Subject: 2024/92236 at location Wood Street Mills, Wakefield Road, Scissett, Huddersfield, HD8 9JS

Please see my commented below regarding ecology.

BNG

Options for deculverting

Title:  
Proposed Site Plan (Floor Plan)

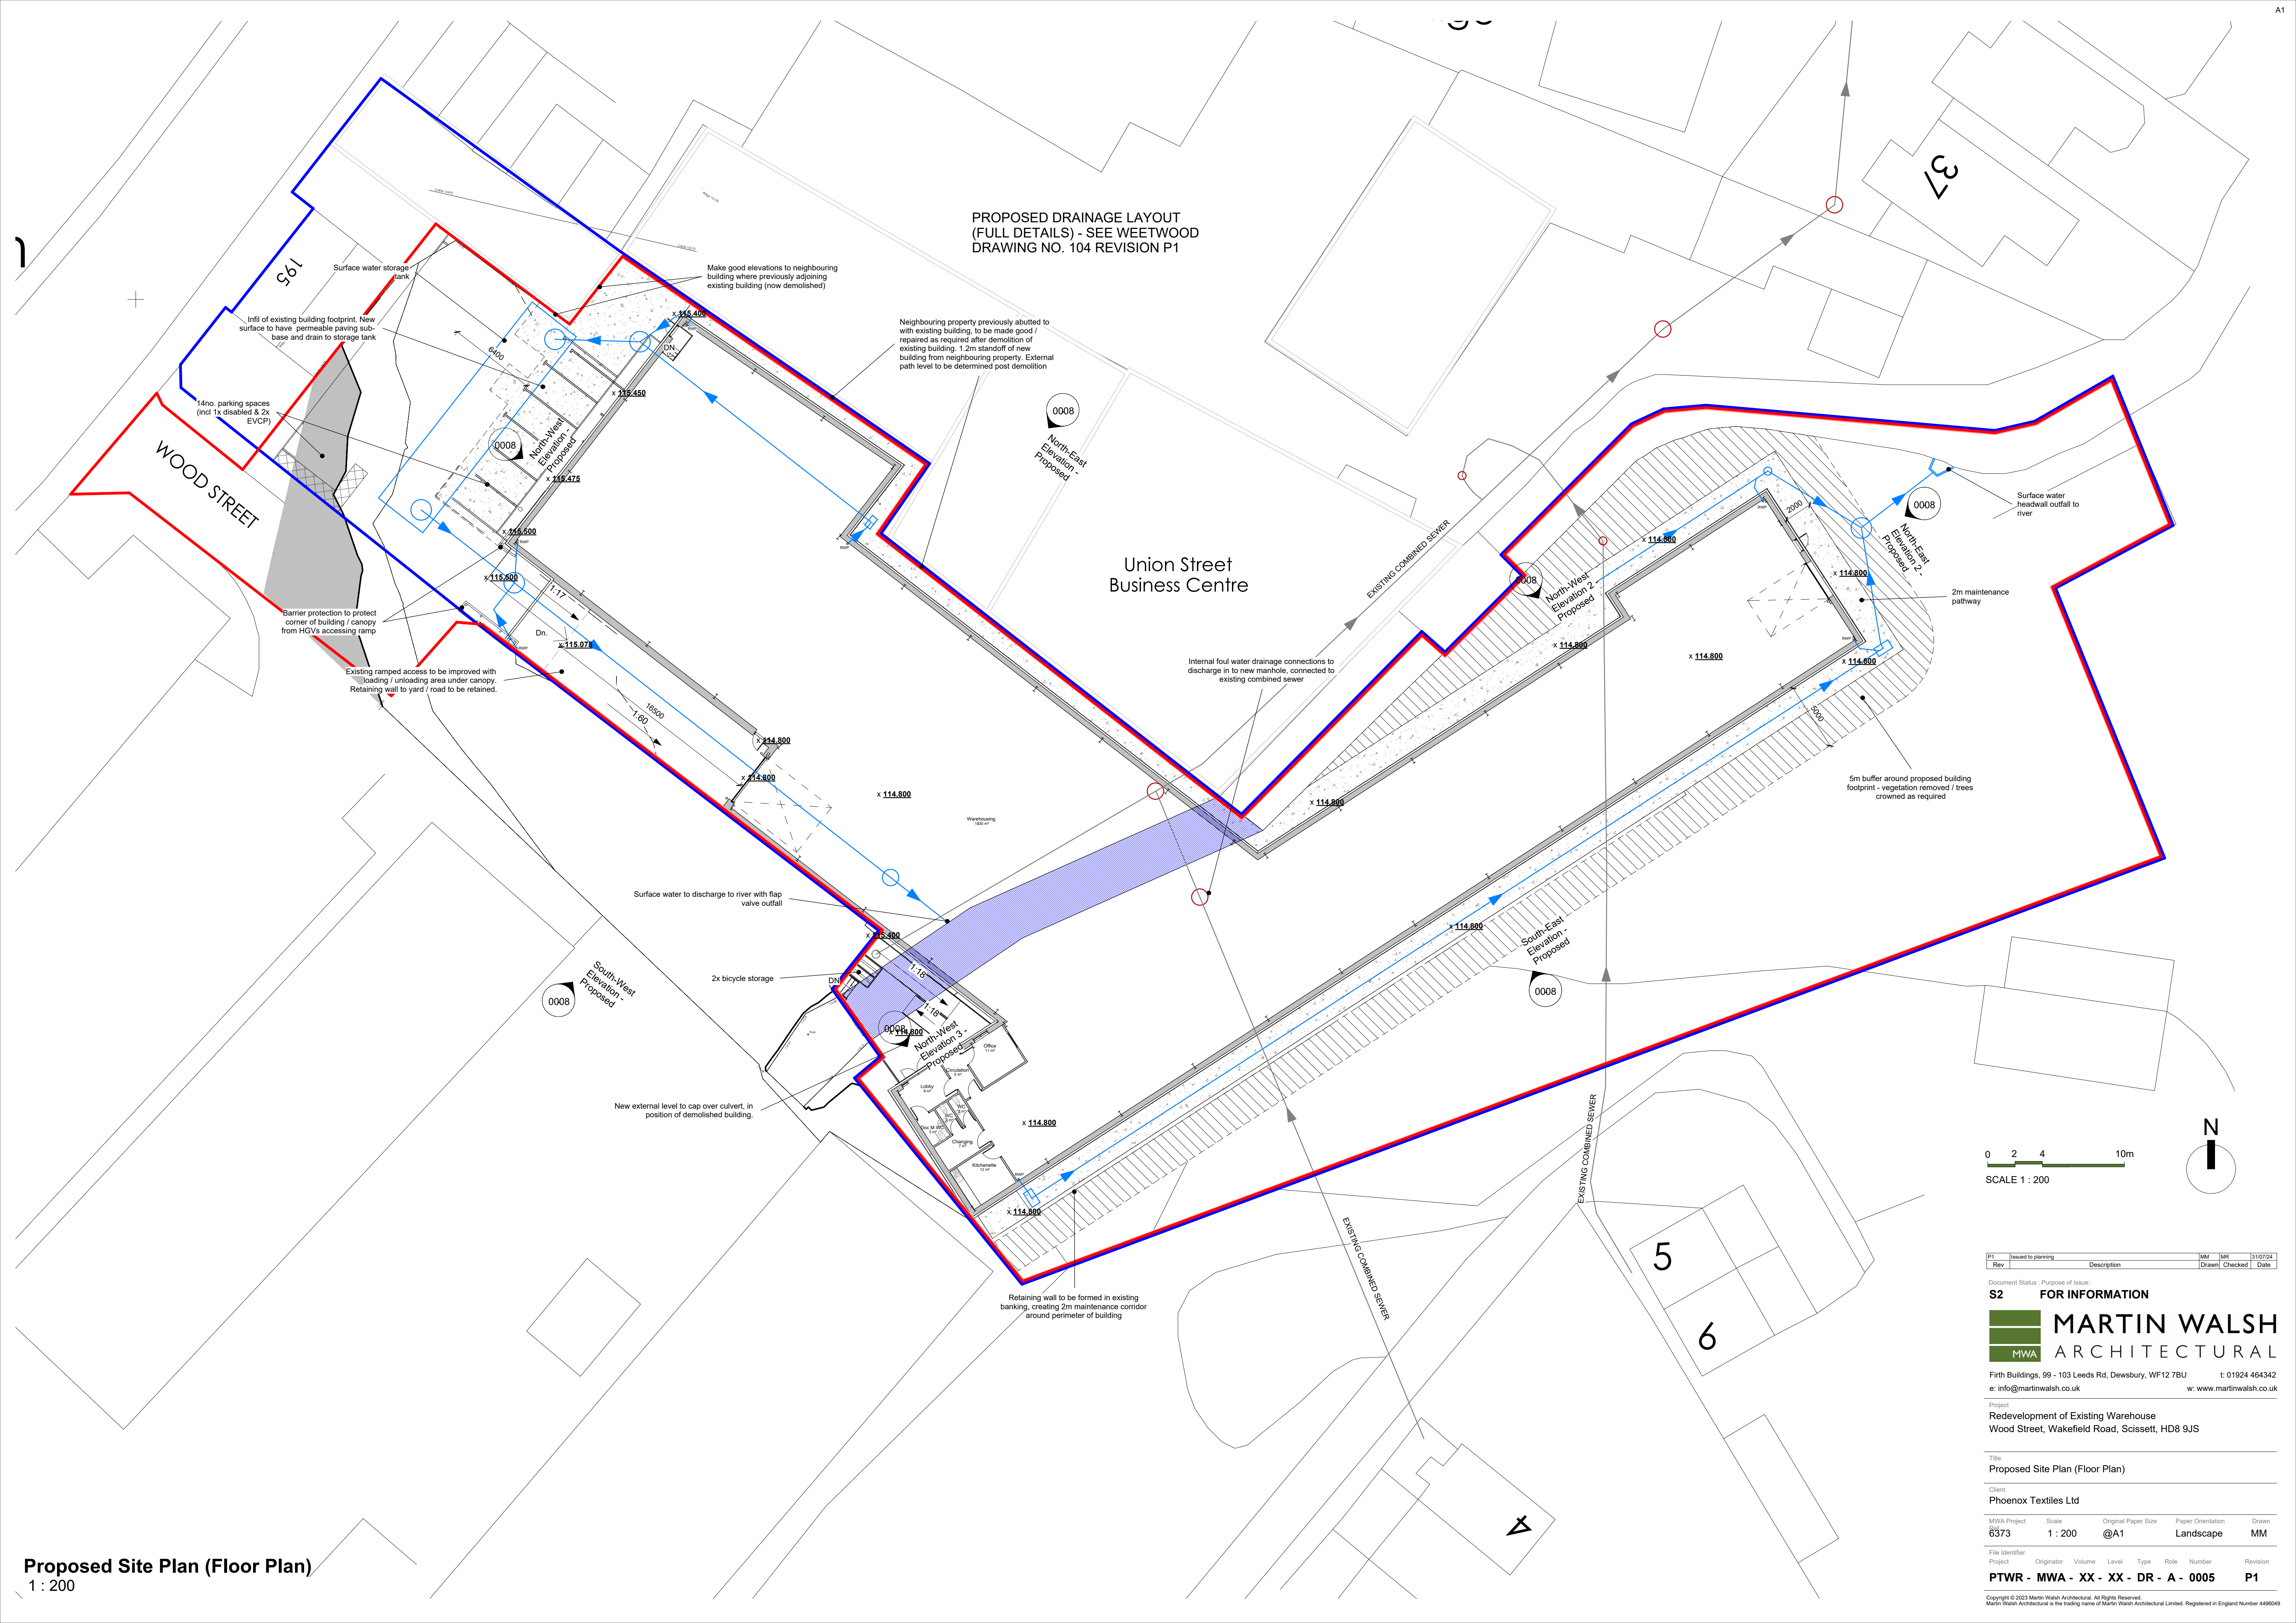
However, Option 3 "Open up the extreme western part of the culvert, which is not affected by new building footprint (partial deculverting)" remains feasible.

The applicant states this option "would require the building to be re-organised – by moving the main pedestrian entrance to the north of the site, where parking is proposed. However, a modest level of deculverting could be achieved."

We disagree with the applicant's justification for discounting this option which states:

"It is suggested that the environmental benefits to be secured from opening up this short section of culvert would be limited - it would remain a relatively urbanised section of river, which would have limited potential to be improved, softened or planted to enhance biodiversity."

We recommend the applicant develops Option 3 as this would deliver 'Policy LP34 Conserving and enhancing the water environment' of the Kirklees Local plan which states that:

Whilst we recognise that deculverting 6 metres of the Dearne through Option 3 will still leave remaining culverted sections along this reach, it will result in localised improvement to hydro-morphology and river habitat in this constrained section of the watercourse. Therefore, the ecological value that Option 3 would provide should not be overlooked.
